**KIRKLEES METROPOLITAN COUNCIL
INVESTMENT & REGENERATION SERVICE**

DELEGATED DECISION TO DETERMINE PLANNING APPLICATIONS

Reference No:	2023/62/93664/E
Site Address:	Four Winds, 2, Highbridge Lane, Skelmanthorpe, Huddersfield, HD8 9JY
Description:	Erection of extensions and alterations (modified proposal)
Recommending Officer:	Elenya Jackson

DECISION - REFUSED

title **General Arrangement as Proposed**
number **22014D-03-P04**
scale **1:100 / 1:200**
size **A1**

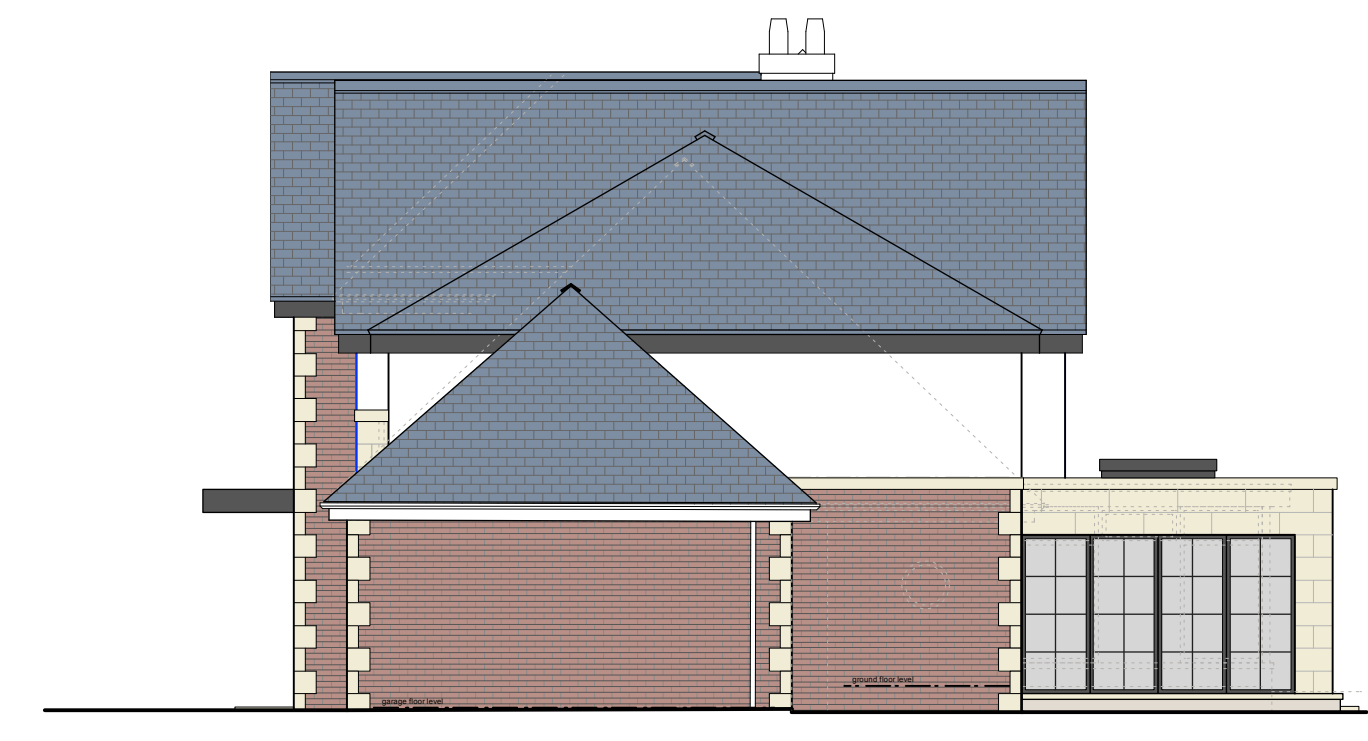
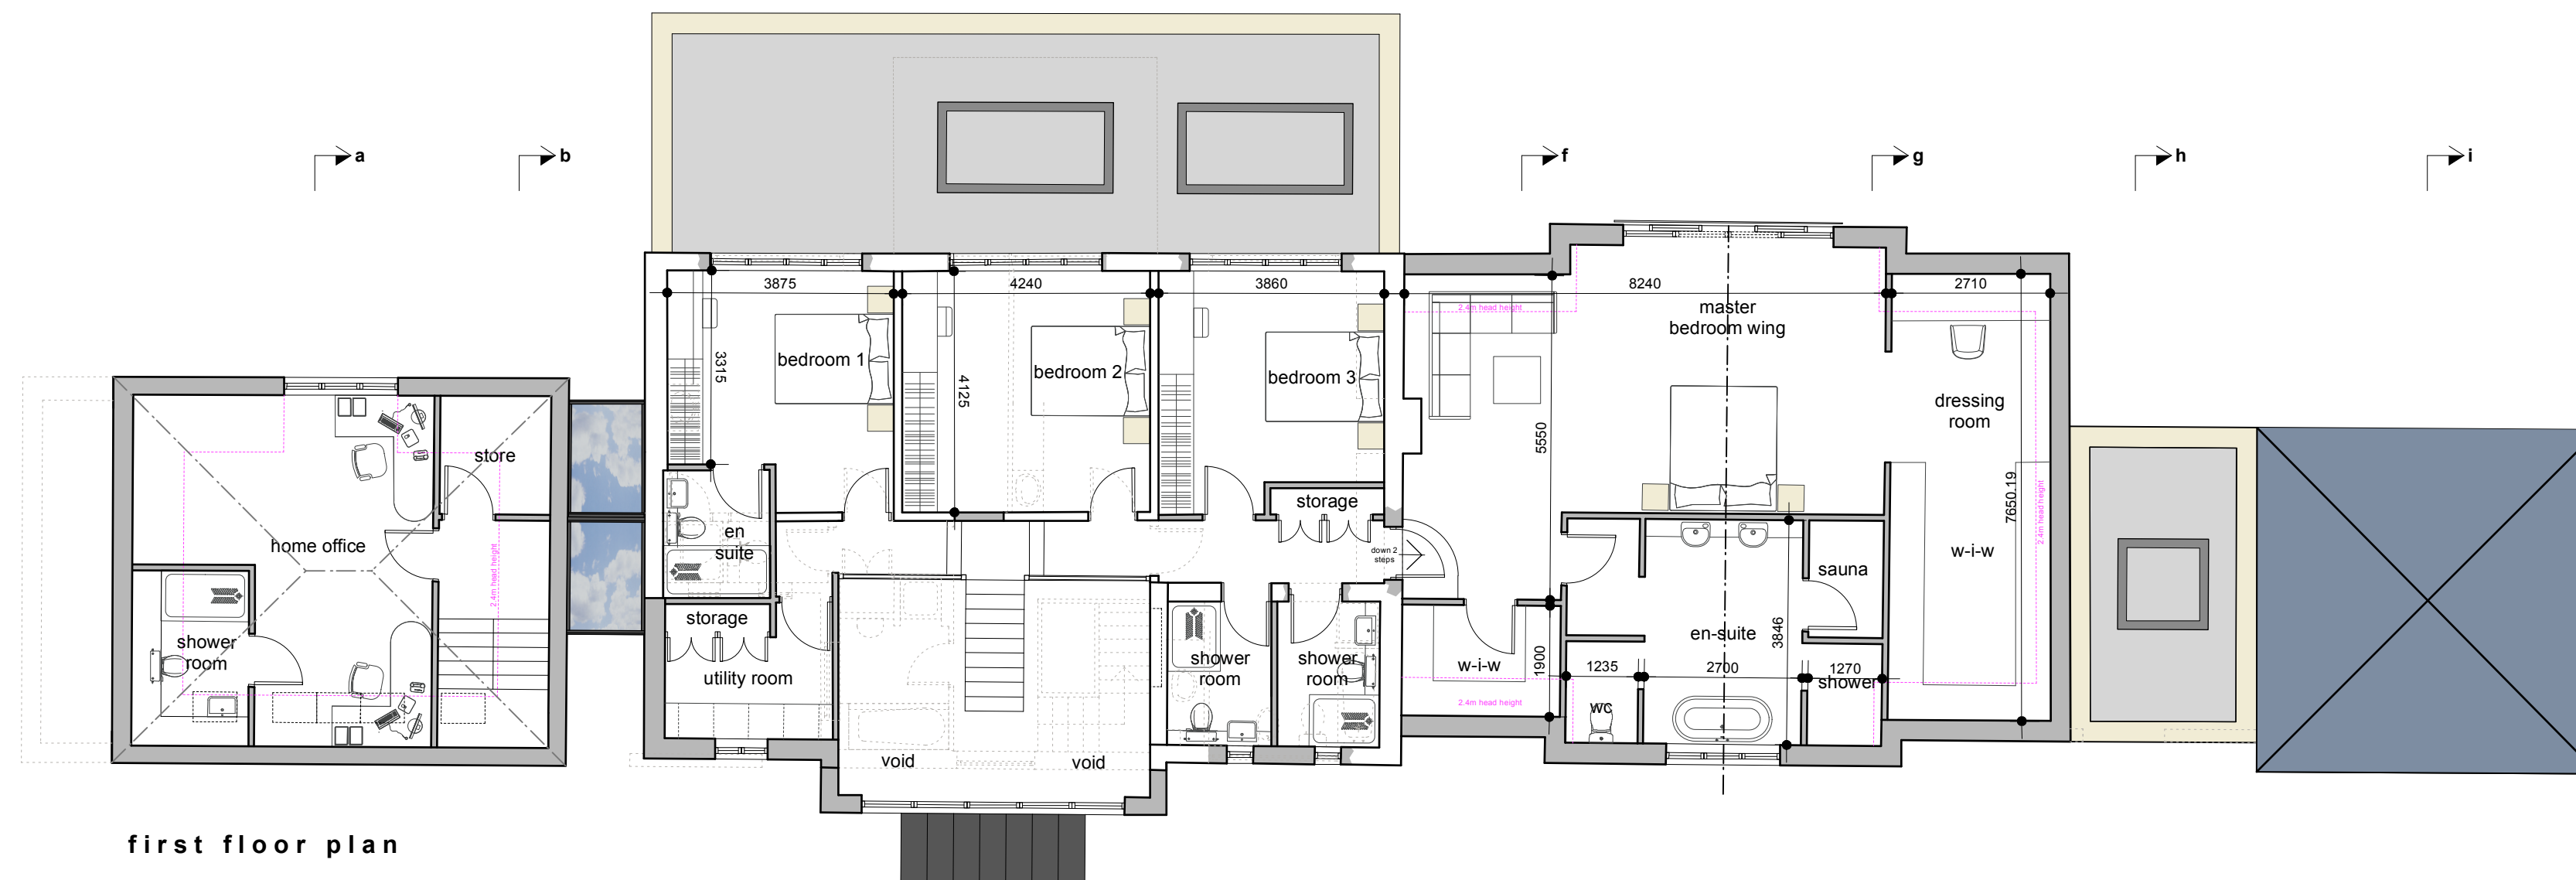
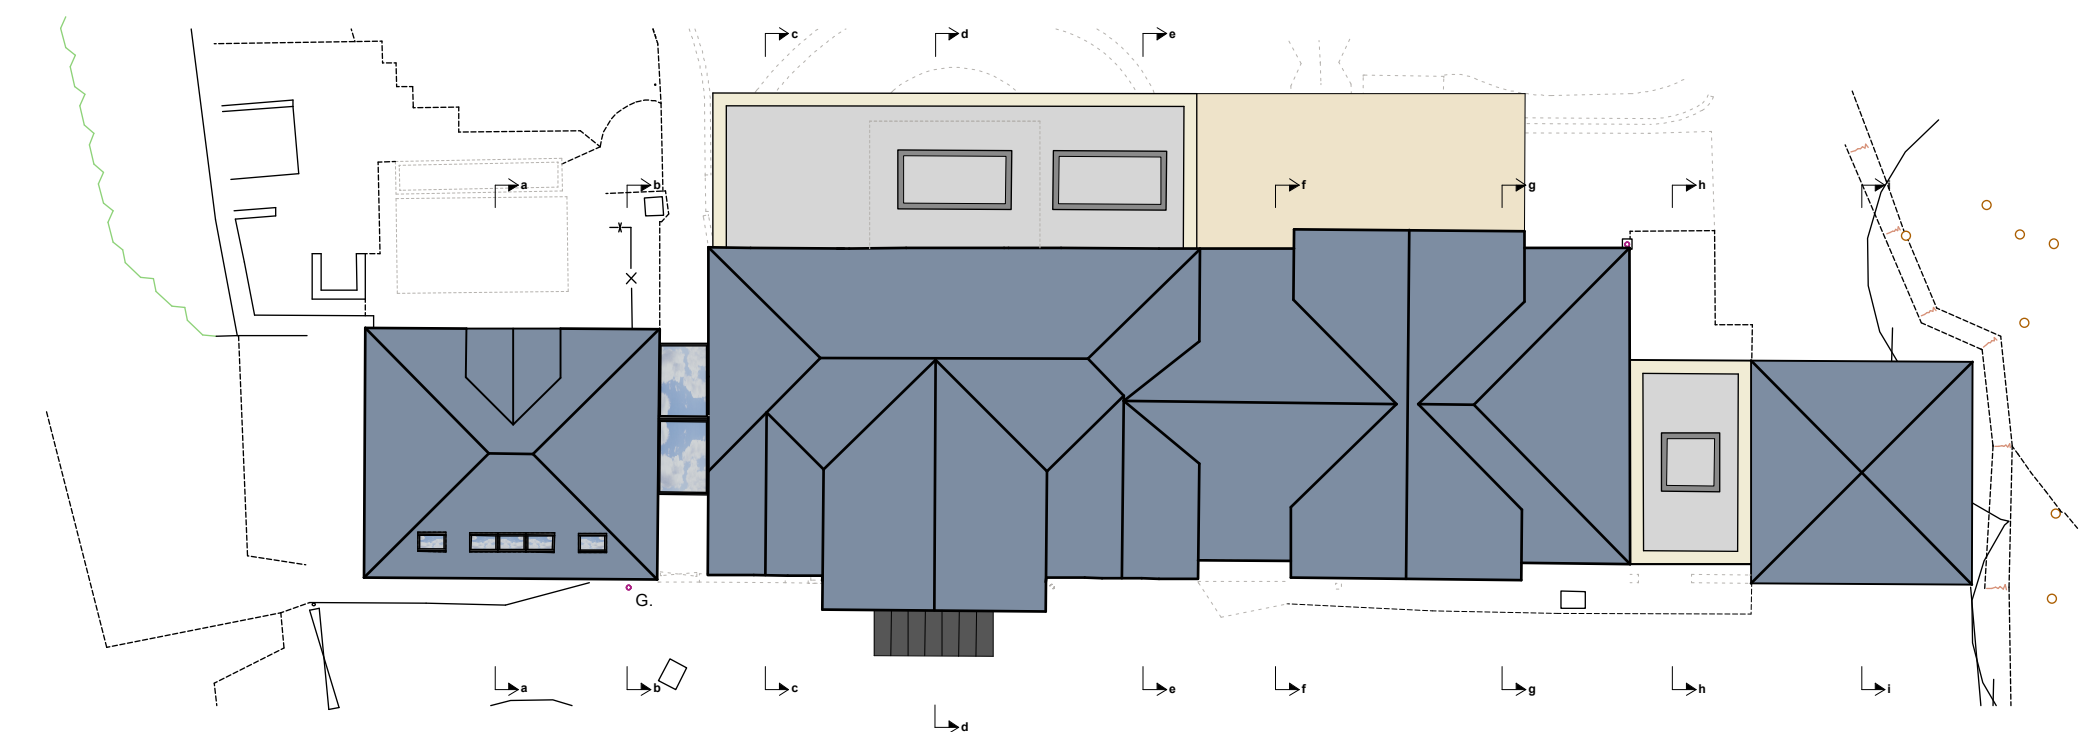
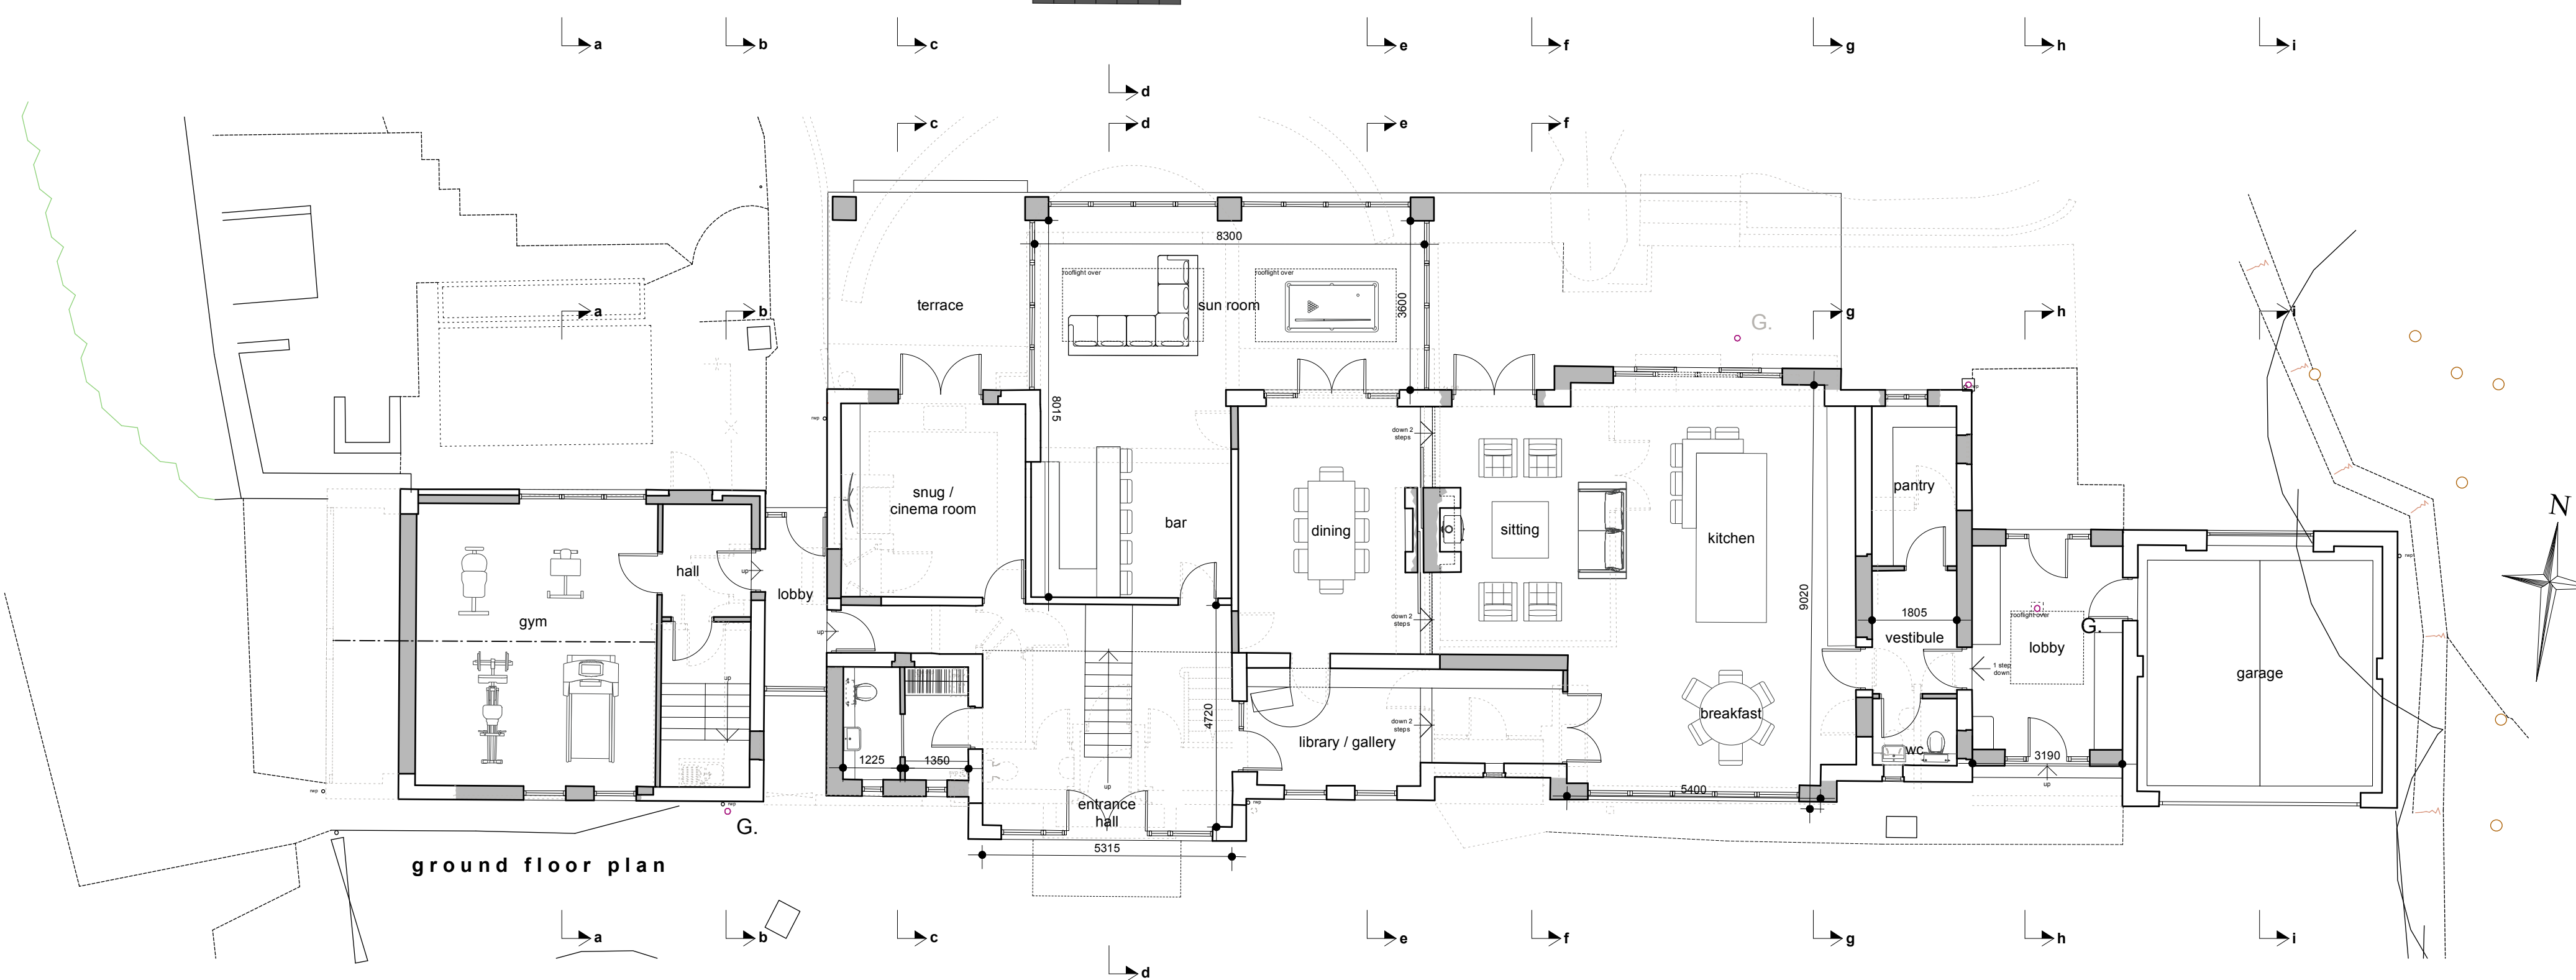
There would be an infill extension to form a lobby between the existing garage and the main dwelling. This would feature a flat roof with a maximum height of 2.9m and a depth of 5.9m (this is matching the previously refused application)

The proposal would add a first floor to the previously approved single storey side extension and introduce a two storey gable end to the principal elevation of the dwelling. The proposal would increase the eaves height of the single storey side projection by 2.3m to 4.8m. This appears consistent with the previous application.

The gable end to the rear(southern elevation) would have a maximum height of 8.8m (matching the previous refusal) and the detailing would remain largely the same.

The proposal would amend the existing principal elevation to feature a fully glazed gable end which would project 90cm beyond the principal elevation of the dwelling. This has been reduced from 1.8m. There would be a gable end either side which would have a maximum height of 8.1m, this is consistent with the previously refused scheme.

The proposed side extension would have a 48cm projection to the north and south elevation to enable the construction of a two storey gable ends with a maximum height of 8.1m with an eaves height of 5m. This would be 20cm smaller than the previous scheme. The eaves height has been increased from 2.8m

The existing garage would also feature the introduction of a first floor which would increase the eaves height of the proposal from 3.1m to 4.4m (30cm less than the previously refused scheme which had an eaves height of 4.7m) and the overall height of the garage from 6m to 6.6m (a 1m decrease from the previous scheme)

The proposal would also include the construction of a single storey rear extension and a terrace which would extend 4.2m beyond the rear elevation of the existing dwelling (10cm more than the previously refused scheme) and have a width of 12.7m,

In this particular case, when taking into consideration the scale of the proposed alterations (including the previously approved alterations on site), the proposed development would have a footprint at ground floor level of 387.6m which does not include associated hardstanding and rear terrace. This would represent a 246m² increase at ground floor level from the original planning unit.

The first floor of the property originally had a footprint of 112m² and would increase to 229m² for the main dwelling and 61.8m² above the workshop which officers have been unable to locate a previous permission for. This would represent a 158.9% increase to the first floor footprint of the dwelling.

The combination of the first floor and ground floor additions to the proposal would result in cumulative development on site amounting to 678.4m² across both floors. As the original dwelling was two storeys with a footprint of 112m², this would represent a 505.7% increase to the footprint of the dwelling.

Subsequently, the overall volume of the dwelling would be substantially increased, and the proposal would result in disproportionate additions over and above the size of the original building. It is therefore considered that the proposals impact on the openness of the Green Belt, both spatially and visually, is considered to be unacceptable'.

It is the case the submitted plans and that of the design and access statement, it is clear that the original building has already been substantially extended and the proposal would result in significant and disproportionate additions over and above the original dwelling. The proposal would therefore fail to comply with Policy LP57(a) of the Kirklees Local Plan and the aims of Chapter 13 of the NPPF as the original house would not remain the dominant element.

In addition to the above, it is considered that the increased sense of scale created by the increase to the maximum height of the proposal, coupled with the introduction of two storey gable ends and roof alterations would result in an overly vertical emphasis/contrast with the existing development. The proposal would subsequently result in the application dwelling appearing incongruous in the context of the host dwelling.

The proposal would fail to comply with Policy LP24 of the Kirklees Local Plan (a) in terms of the form, scale and layout and (c) as the extension would not form a subservient addition to the property in keeping with the existing building; nor advice within the House Extensions and Alterations SPD, specifically KDP1 with respect Local Character, taking into account the rural local area. In addition, the proposal would not accord with KDP2 with regards to the impact on the original house as the design of the extensions is neither well balanced, proportionate or sympathetic to the existing house or the aims of chapter 12 and 13 of the National Planning Policy Framework

1. The proposed extensions, taking into account earlier extensions to the dwelling, would be disproportionately large in relation to the original part of the building and represent inappropriate development, which is harmful to the Green Belt and the visual amenity of the area. The proposed development is therefore contrary to Policy LP57 of the Kirklees Local Plan and paragraph 154c of the National Planning Policy Framework.

1. The proposed extensions, by virtue of their scale and design, would not be subservient to the original dwelling and would detract from the character and appearance of the dwelling. To permit the proposals would be contrary to policies LP24 and LP57 of the Kirklees Local Plan, advice within the House Extensions and Alterations SPD and Chapters 12 & 13 of the National Planning Policy Framework.
